Our ref: P01106445

13 October 2019

**LAND ADJ TO PROMISED LAND FARM, WENDLEBURY ROAD, CHESTERTON,  
OXFORDSHIRE  
Application No. 19/01746/OUT**

**Historic England Advice**

APPLICATION 2
PARAMETERS PLAN 02
BUILDING HEIGHT

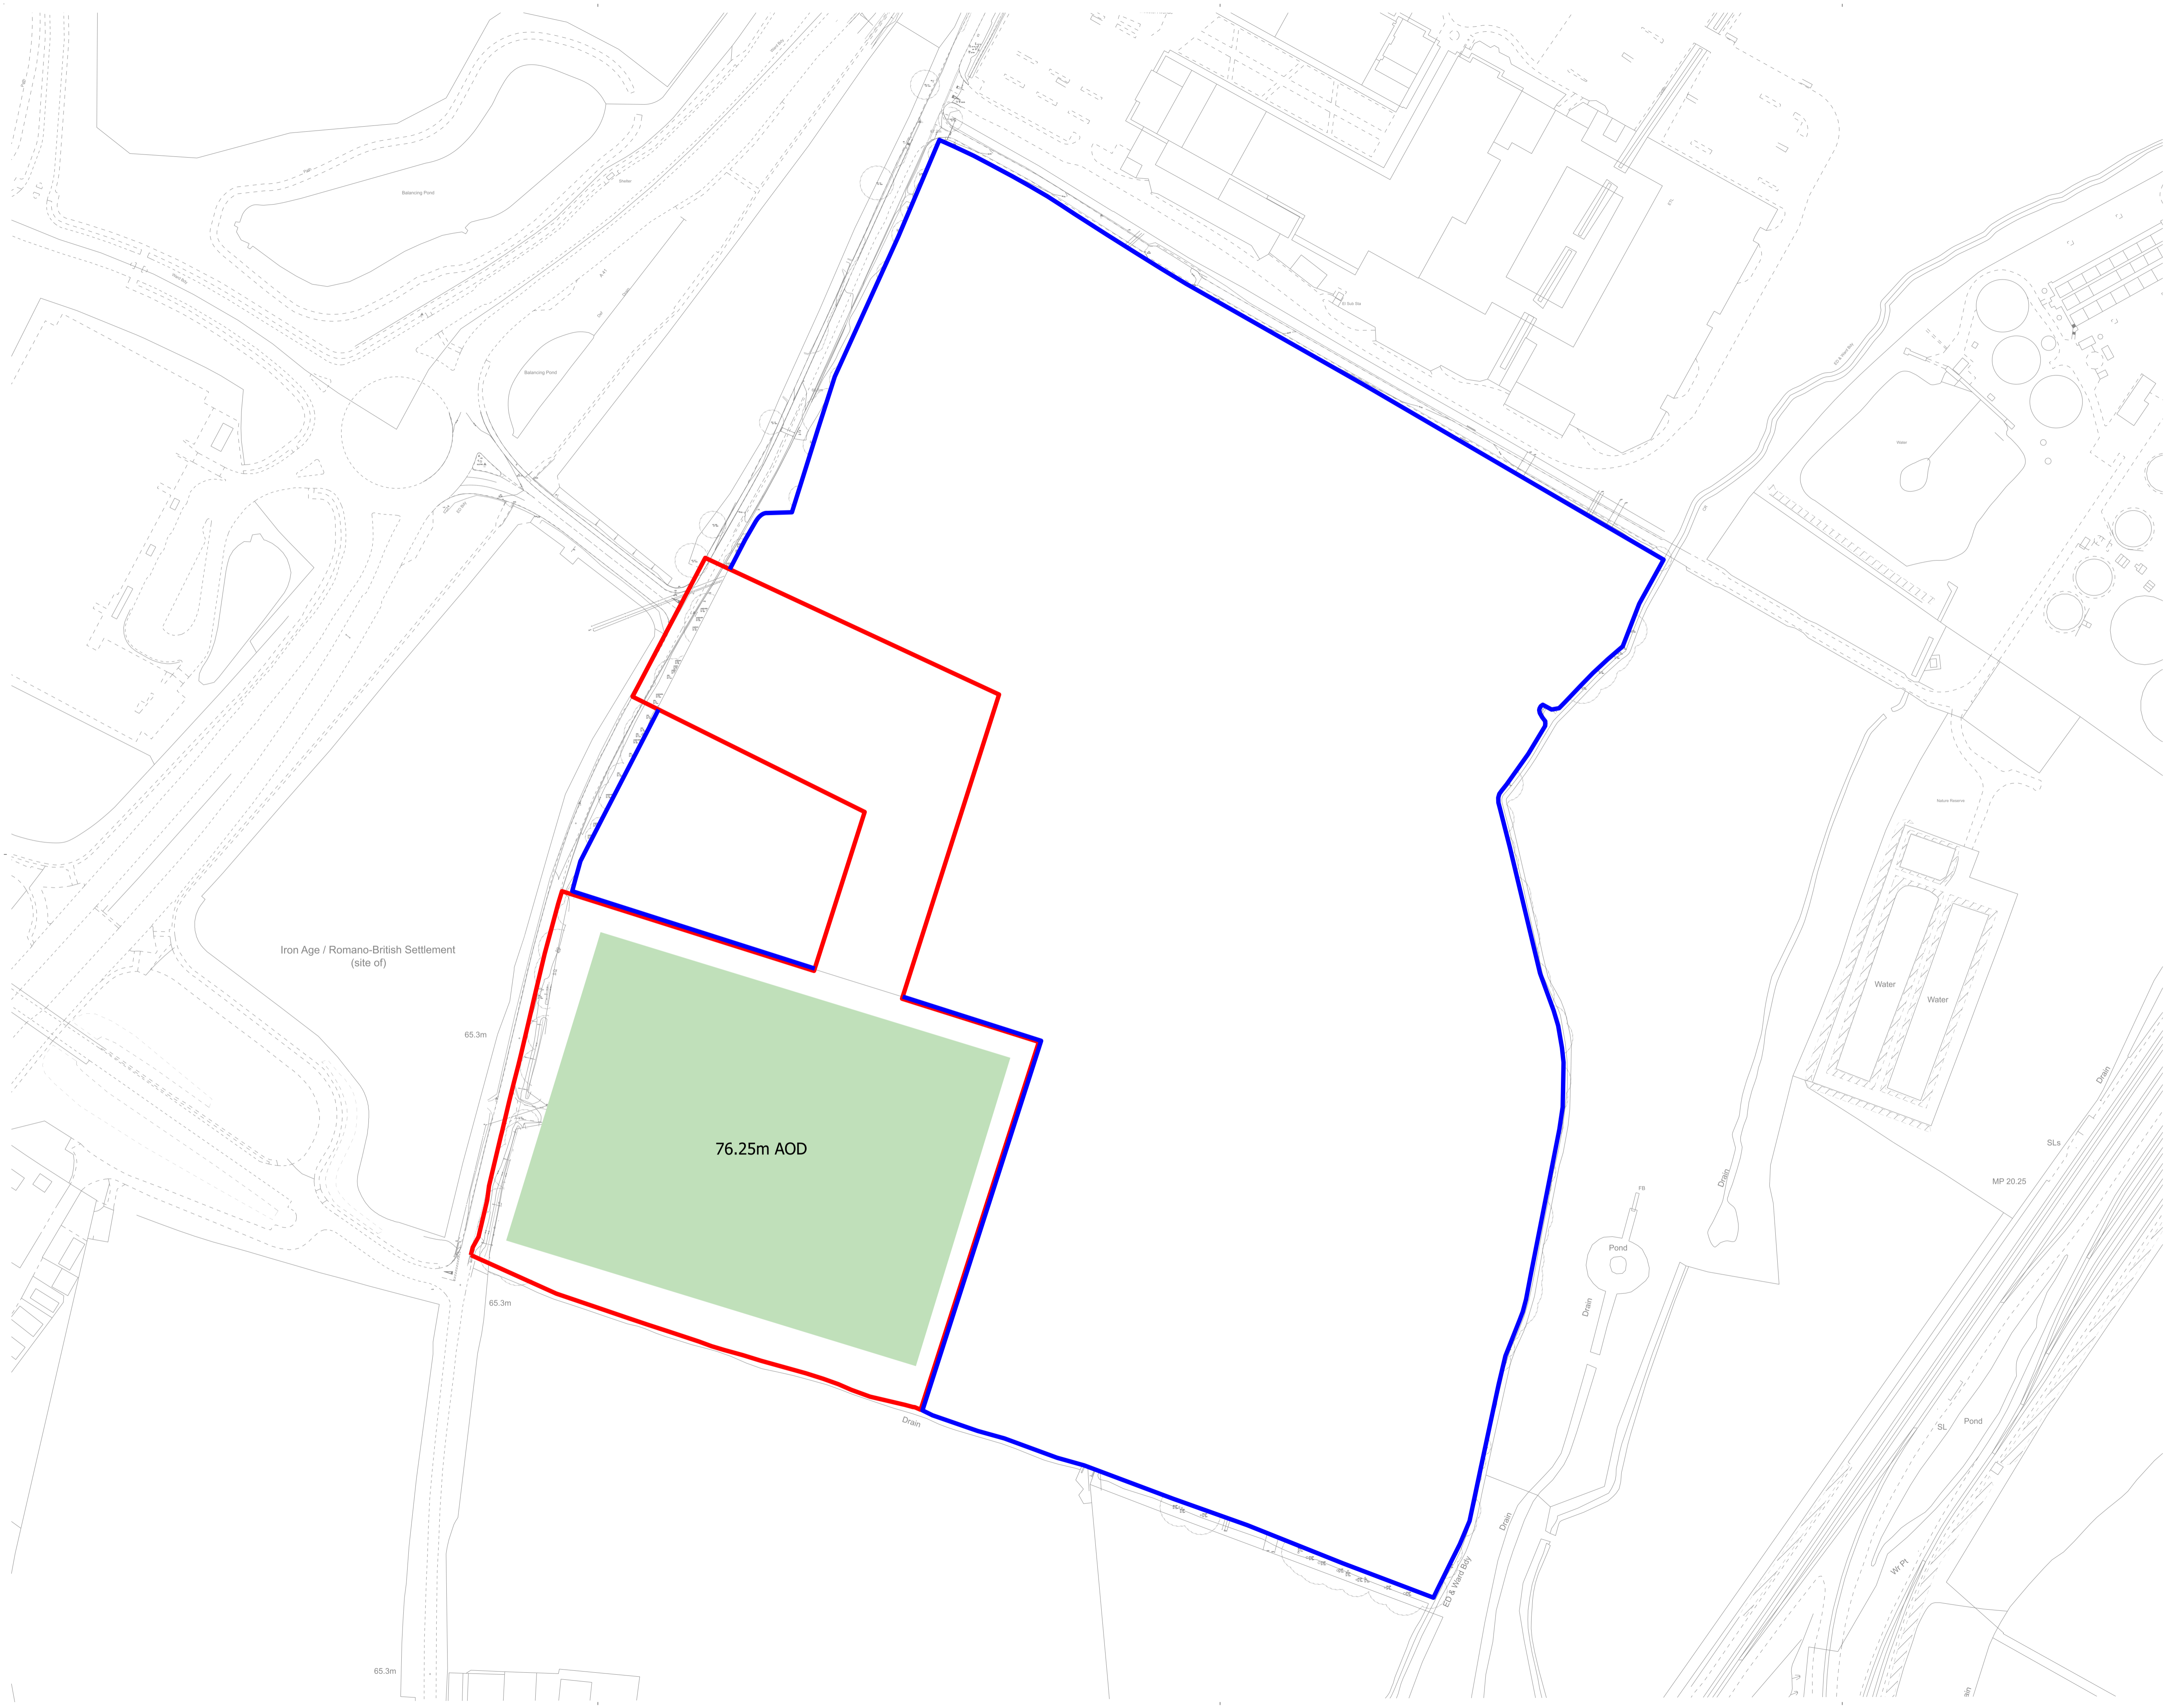
The development will infill some of the open land adjacent to the monument and therefore has the potential to impact on the significance of the scheduled monument, as contributed to by its setting. This was recognised and clearly stated in para, 7.6 of the Heritage DBA prepared in 2016. However, the Environmental Statement excludes built heritage and archaeology on the grounds that they were: '*not likely to give rise to significant environmental effects*' (ES, *Non-Technical Summary*, 3.2). This decision derives from an informal scoping note prepared in 2018. No formal scoping opinion was sought from your council, and Historic England were not consulted at any point, despite the adjacent scheduled monument and despite consultation with HE being recommended in the DBA. The submitted Planning Statement contains a short section which asserts that the development will cause not harm to the monument's significance, but provides no supporting information in the way of view analysis, wireframe outlines etc.

- Potential impact should be properly assessed taking account of the significance as discussed above. Sufficient view analysis and or wireframe views should be provided for the impact on views, particularly views out from the monument, to be understood.
- Consideration of existing screening should consider impermanence and seasonality, as recommended in Historic England's setting guidance quoted above.
